Consultation Response from KC Strategic Housing
2021/91871 Land adj, High Street and Challenge Way, Hanging Heaton, Batley

Application for: Erection of residential development including access and associated infrastructure

Date Responded:
20/07/2021

Responding Ref: SH/21/91871

SITE PLAN

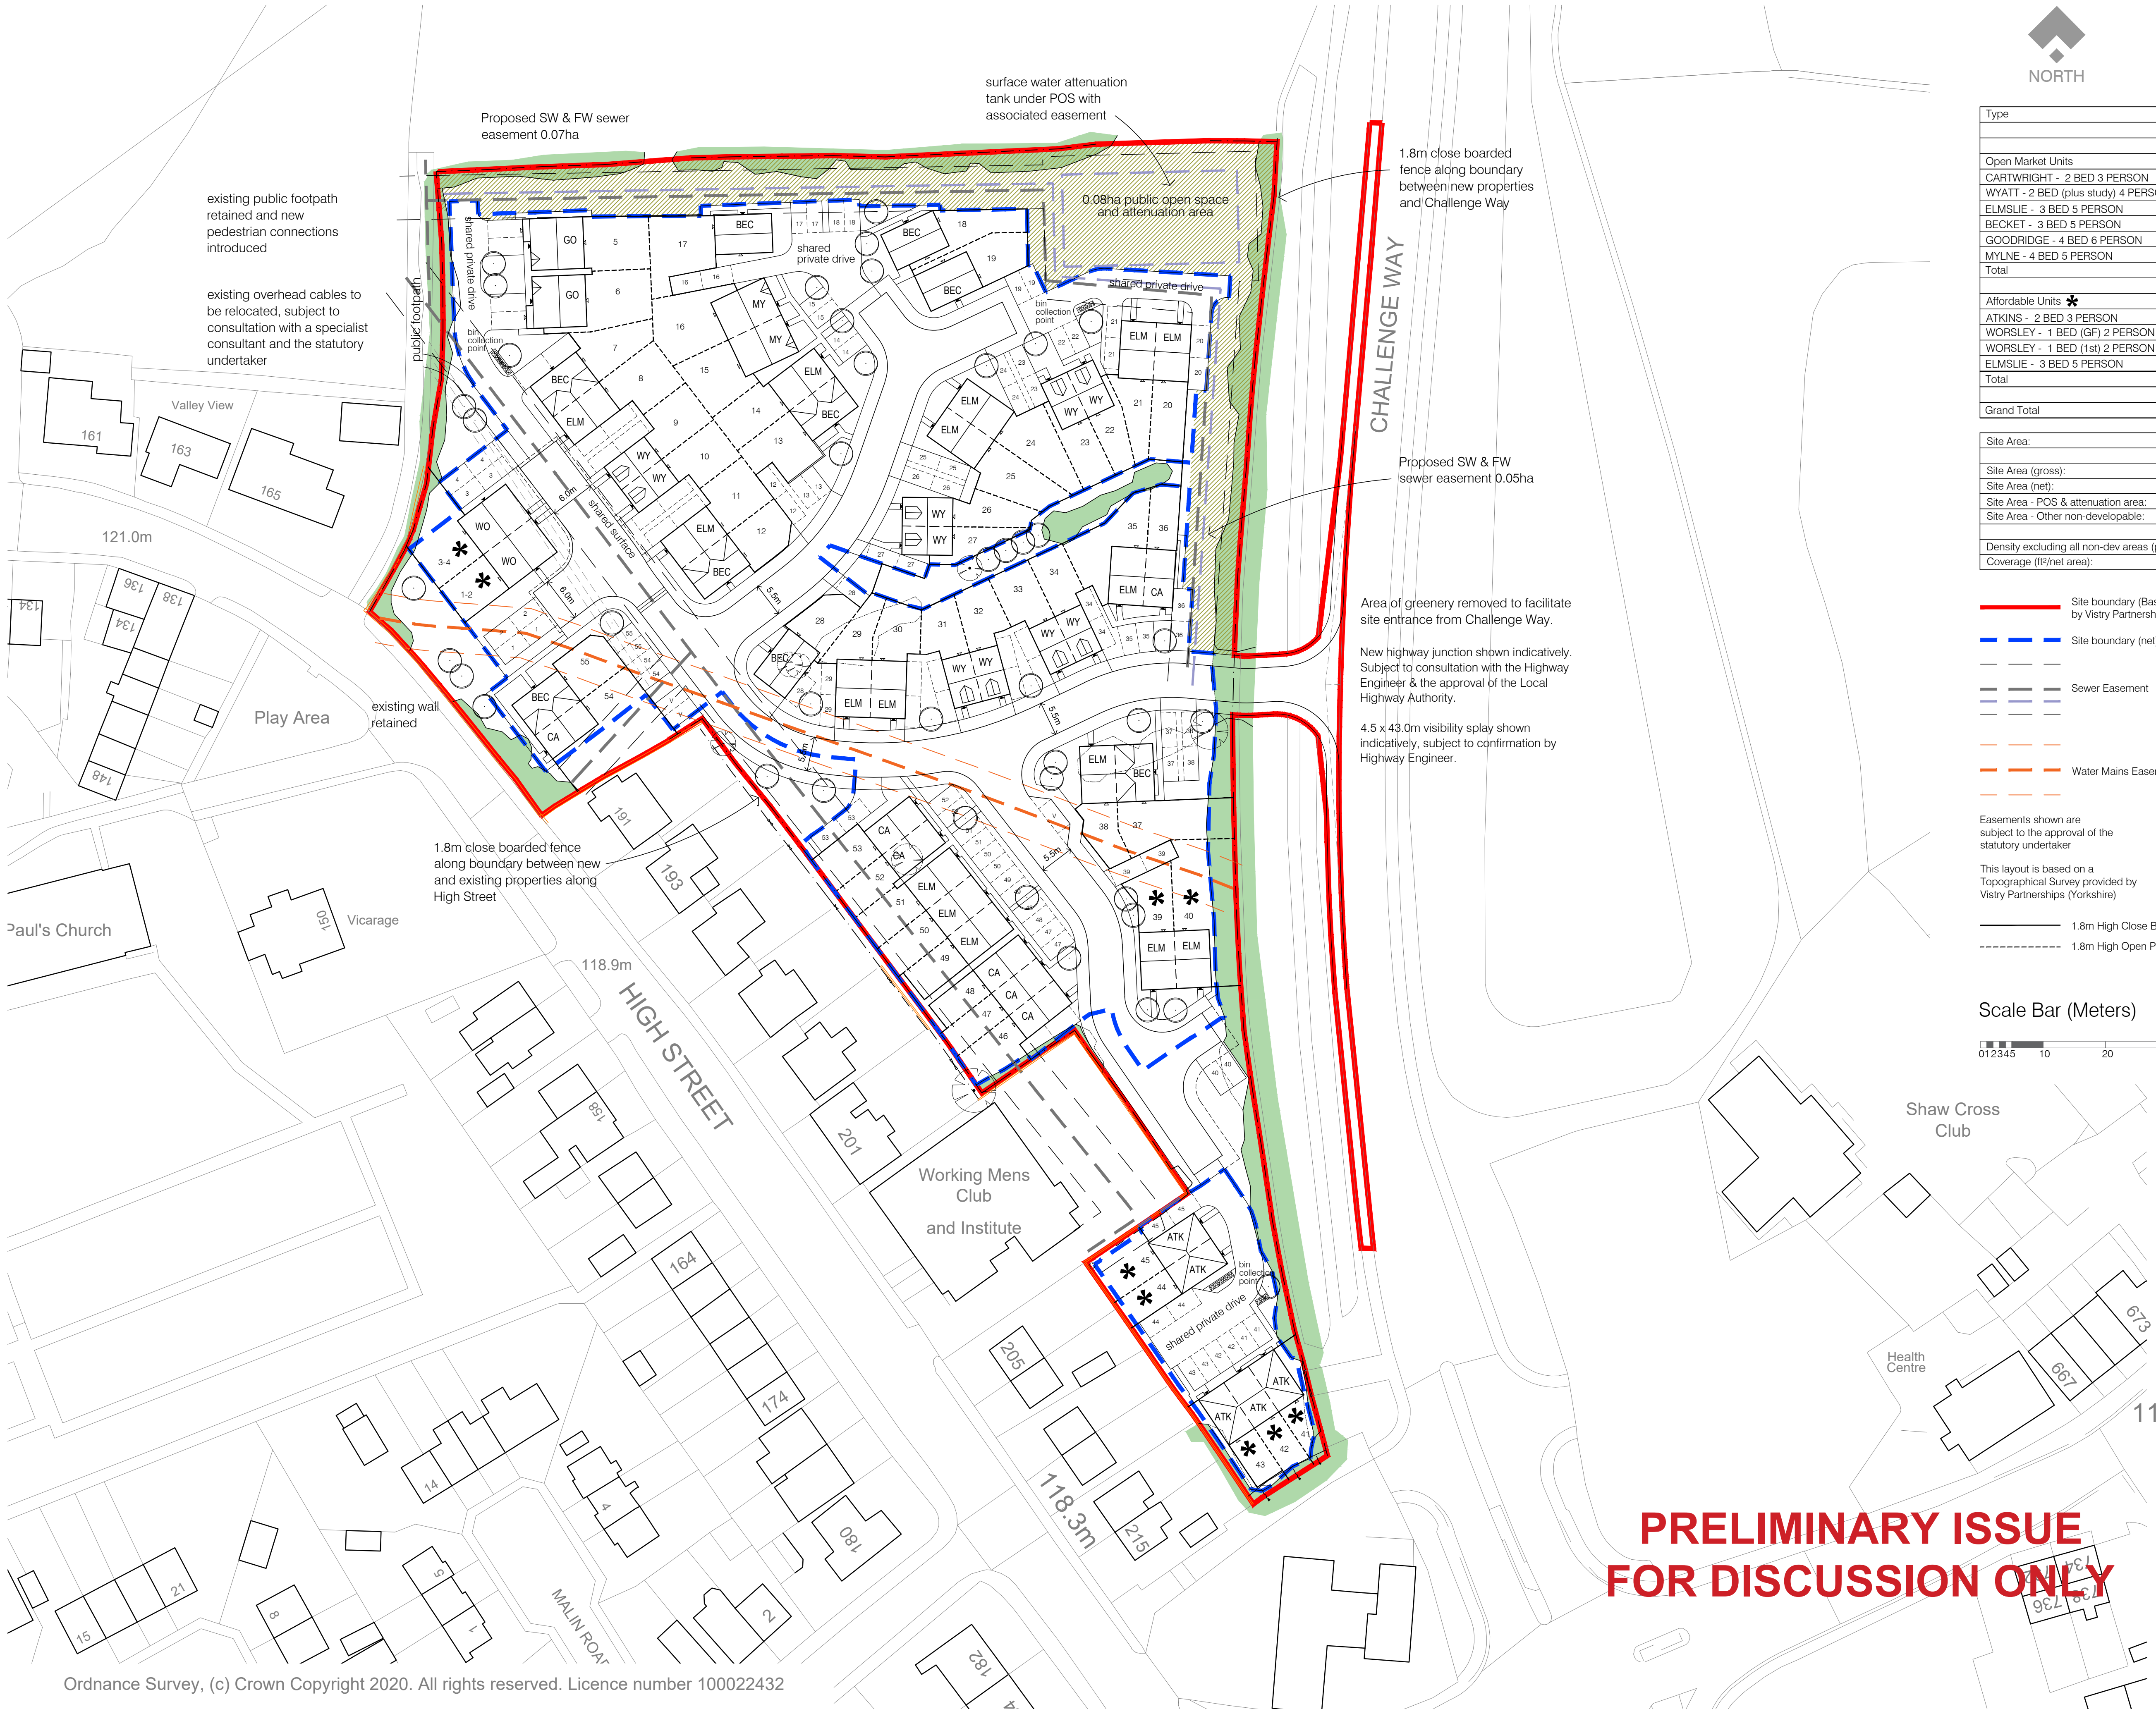
The applicant proposes a mix of 1, 2, 3 and 4 bed homes. Whilst the increase of 2 and 4 bed units is welcomed, all 4 of the additional 1-bed units on the development are allocated as affordable, meaning they are likely to be distinguishable from the market housing. The proposed affordable provision comprises 4 x 1 bed dwellings, 5 x 2 bed dwellings and 2 x 3 bed dwellings.

The current designs show the affordable units located primarily at one corner of the development – these require further distribution as outlined above.
